Tel: 01903 737756
Email: planning@arun.gov.uk
www.arun.gov.uk/planning
Please ask for: Ms Iqraa Malik
Email: iqraa.malik@terraquest.co.uk
Telephone: 0121 234 1390
Our Ref: AW/201/25/HH
Your Ref:
Date: 8th September 2025

Application for Planning Permission for Works or Extension to a Dwelling

Development: Single storey rear extension with steps, side extension to garage and alterations to front porch and fenestration.
Location: Victory 12 Selwyn Close Aldwick PO21 5RT

Block Plan
Scale 1:500

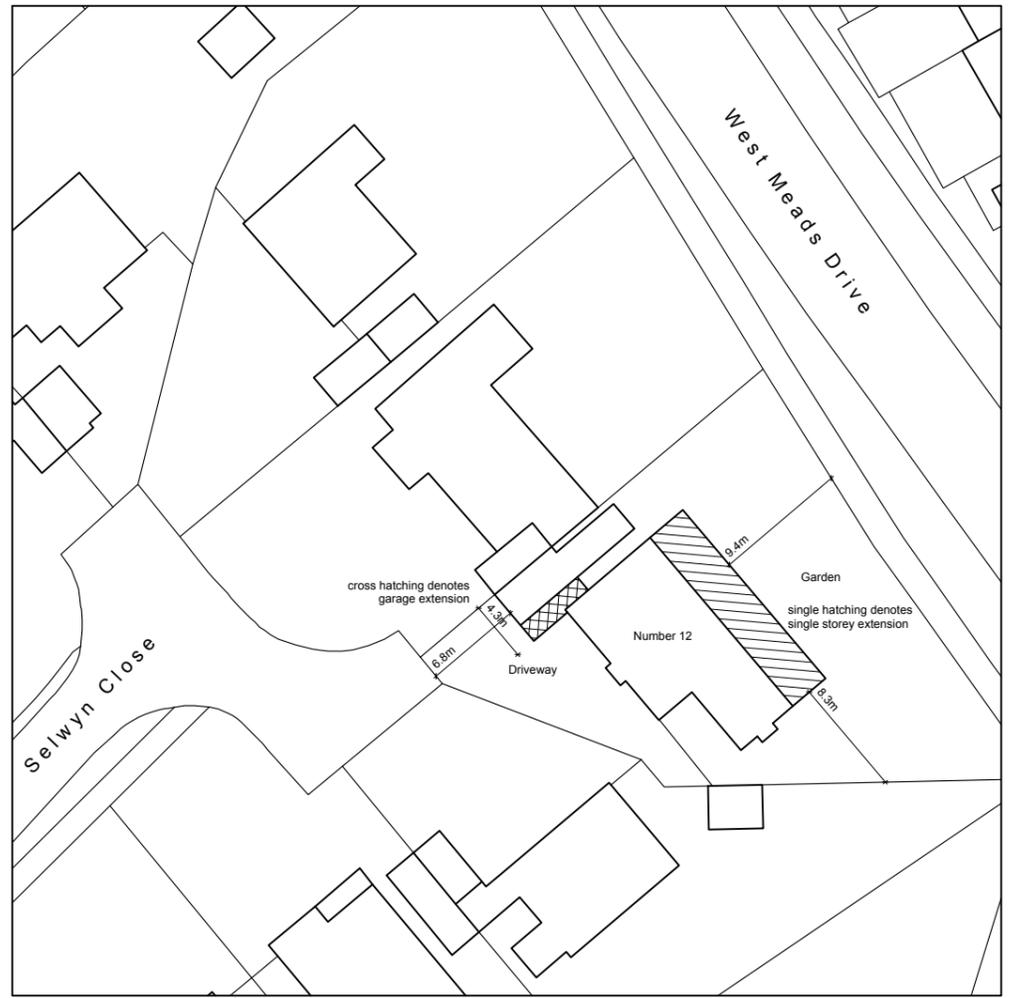
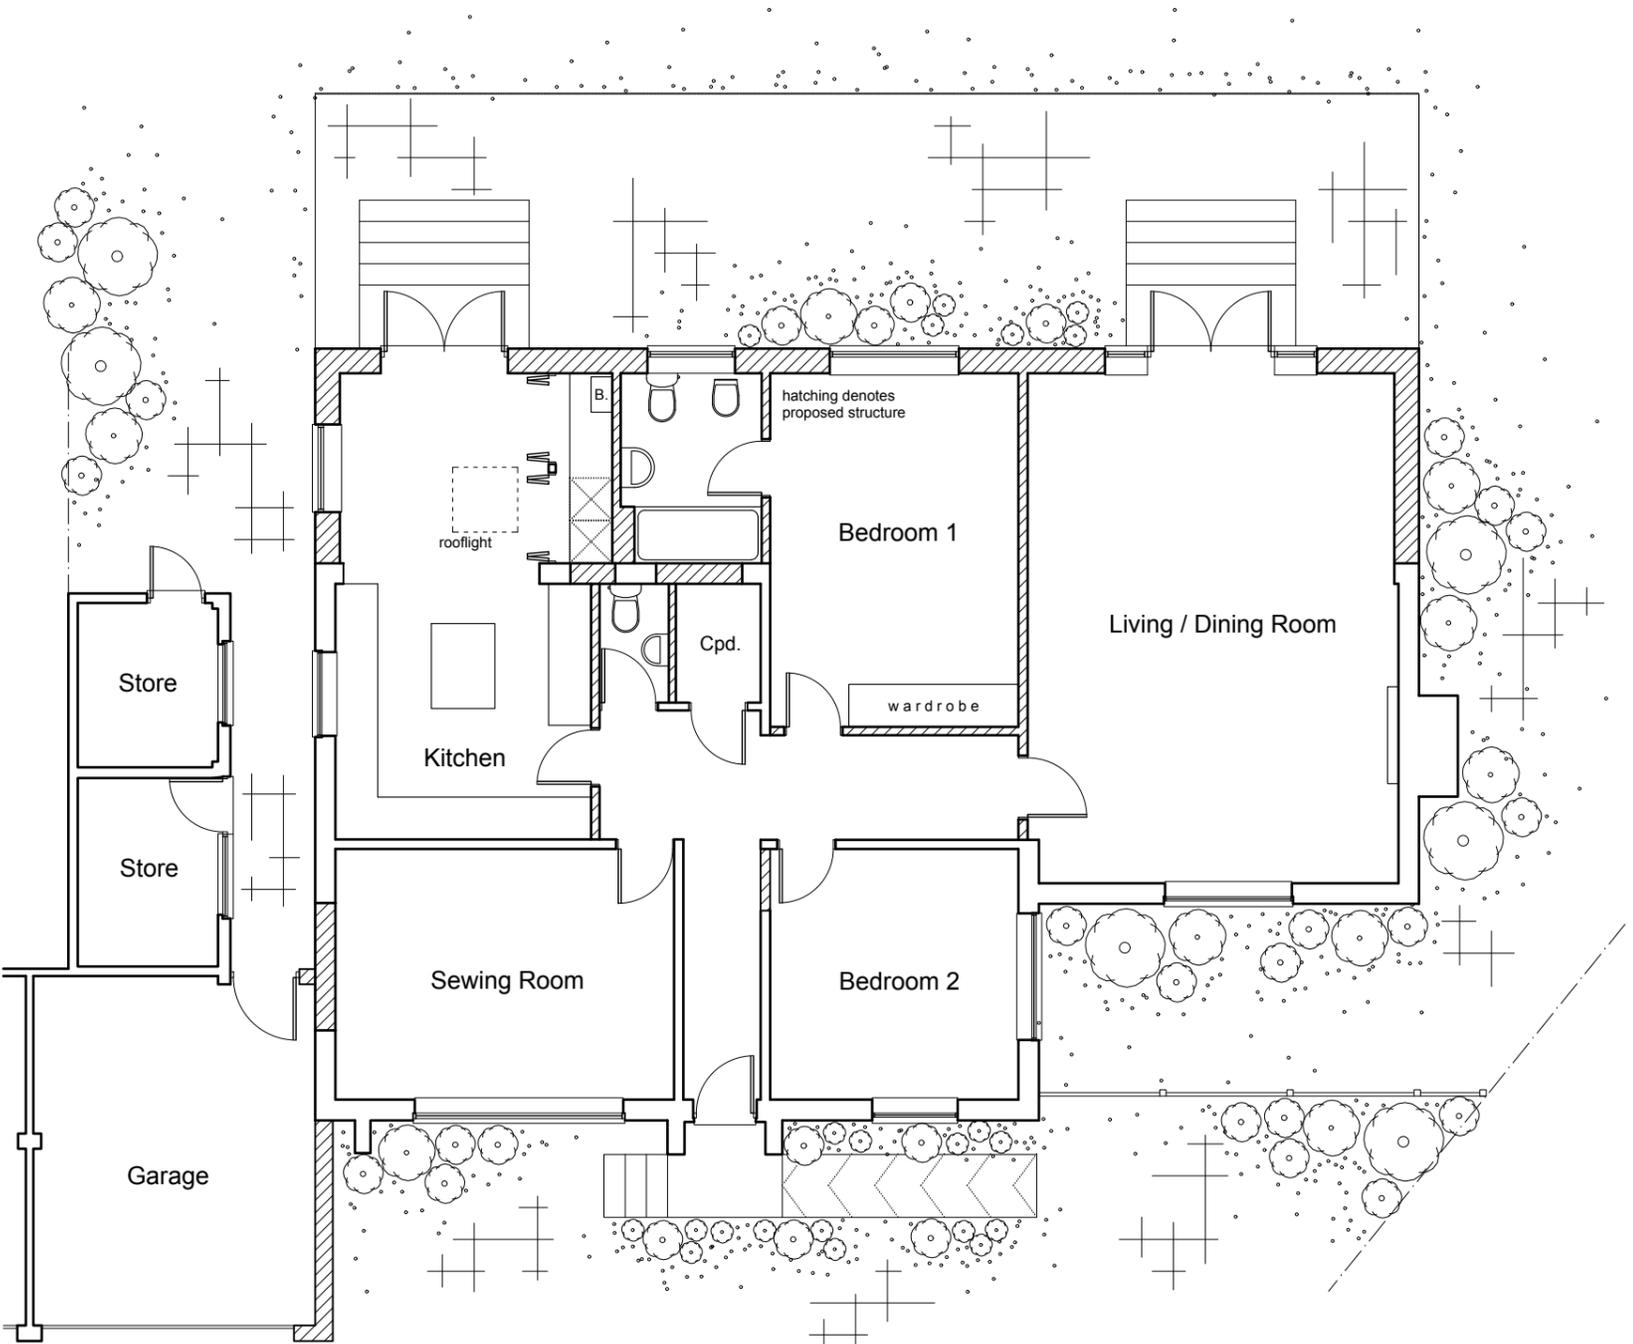
The 4.4m and 9.5m dimensions on the block plan do not measure to scale, please review and amend. Further details of what must be included on the plan can be found in the Validation Requirements List.
